ASSESSMENT REPORT

Commercial and Retail Development – Mount Street, North Sydney MP 08_0241 MOD 6

Contextual Elevation - South

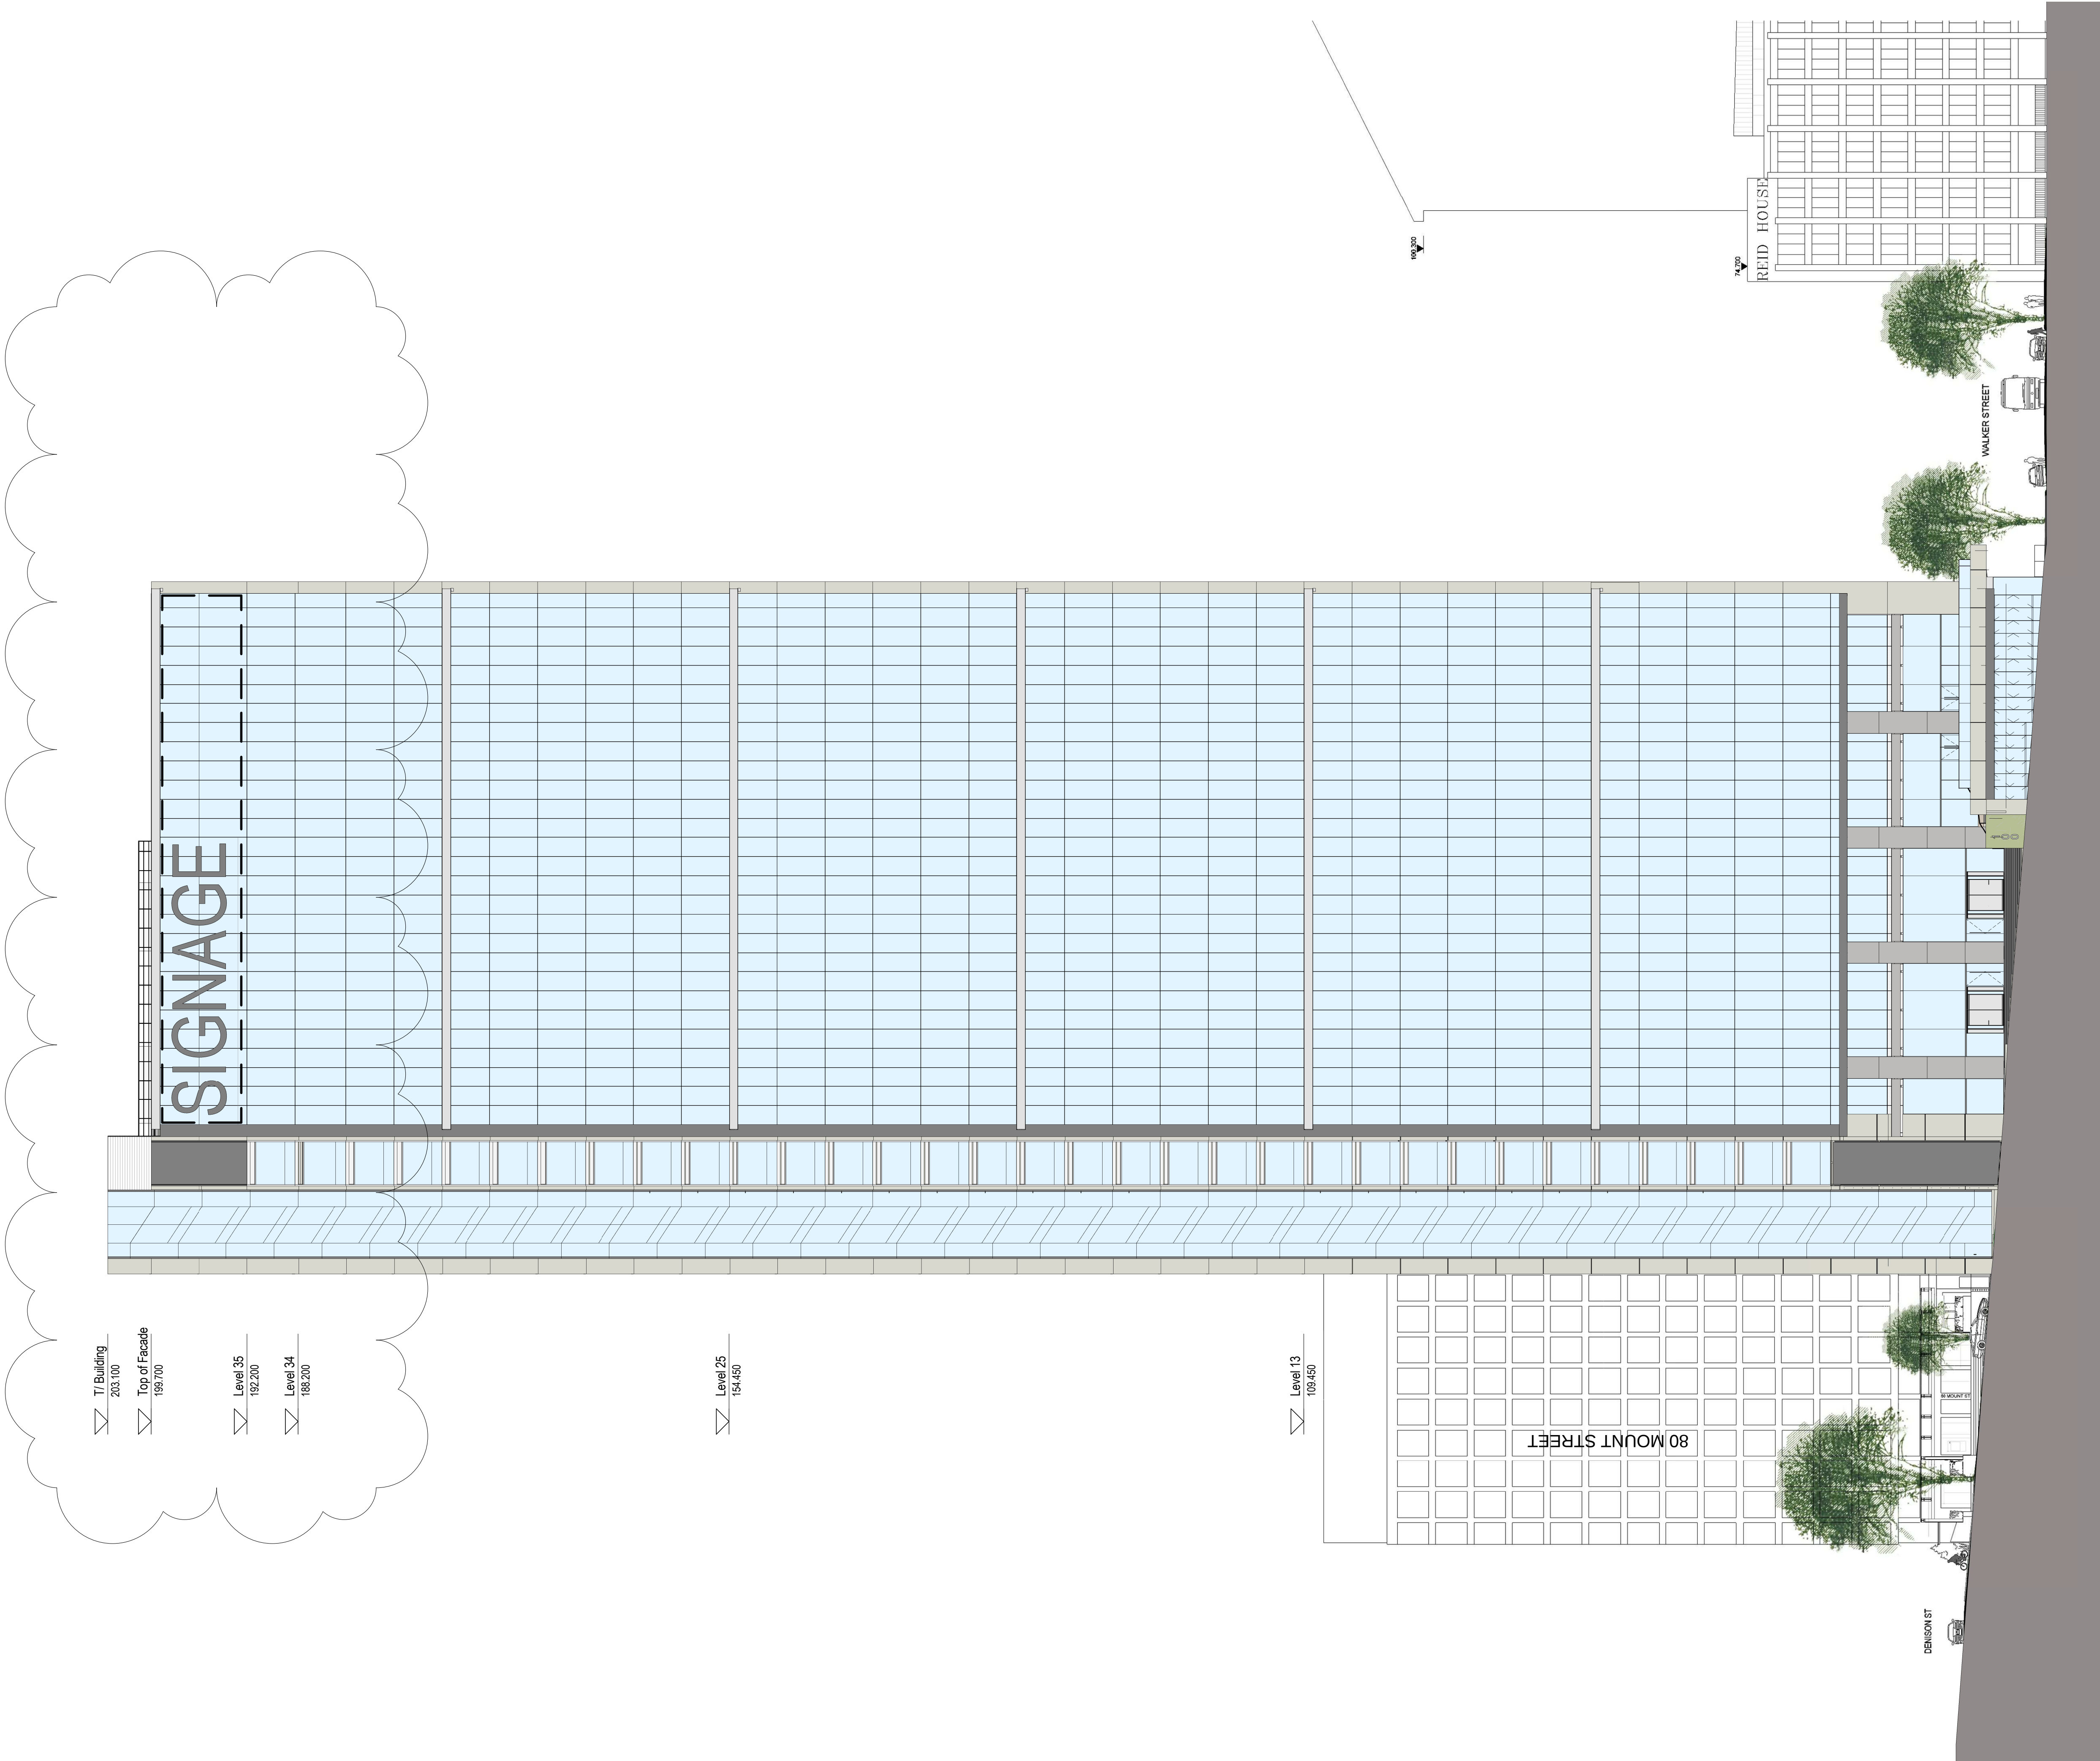
Issue	Consideration	Recommendation
<i>Additional roof level plant and services</i>	- The proposed modification seeks to increase the extent of roof level plant and services, with the enlarged plant and service area re-located to the western edge of the building. - Concern is raised in the public submission that the proposal would exacerbate the non-compliance with Council's height controls, set an undesirable precedent for other building sites and result in amenity impacts in terms of loss of solar access, views, increased overlooking and sense of enclosure. - Council have raised no concern with the proposed roof level changes. - The Department notes a maximum height control of RL 195 applies to the site under North Sydney Local Environmental Plan 2013 (NSLEP 2013), however roof level plant to a height of RL 203.1 has already been approved on the site. The proposal does not seek to increase the maximum building height in this regard. - The Department acknowledges the enlarged and relocated service area would be more readily visible than the existing approved roof level plant. However, the Department is satisfied that the proposal would not result in any unacceptable impacts, noting that: - the revisions relate only to a small section at the western edge of the building and incorporate the approved façade materials and finishes so that as viewed from the street level and from other vantage points, the change to the overall appearance of the building would be minor and not readily discernible; - as viewed from the Beau Monde Building, the proposed changes to the western edge of the site are likely to be obstructed from view by an approved new development at 1 Denison Street, located between the two sites; - as a separation of 130 metres exists between the site, and the Beau Monde Building, the proposed minor changes would not result in any unacceptable amenity impacts in terms of loss of solar access, views, increased overlooking or sense of enclosure; - shadow diagrams indicate that the proposed changes would not result in any additional overshadowing of residential dwellings or material impacts to public domain areas; - a wind report submitted with the modification demonstrates that proposed minor changes would have a negligible impact on the pedestrian level wind conditions; and - the building form would continue to be compatible with the dense commercial built form context of the North Sydney CBD. - The Department is therefore satisfied the proposed minor changes to the roof level plant are acceptable in this case.	No additional conditions or amendments necessary.
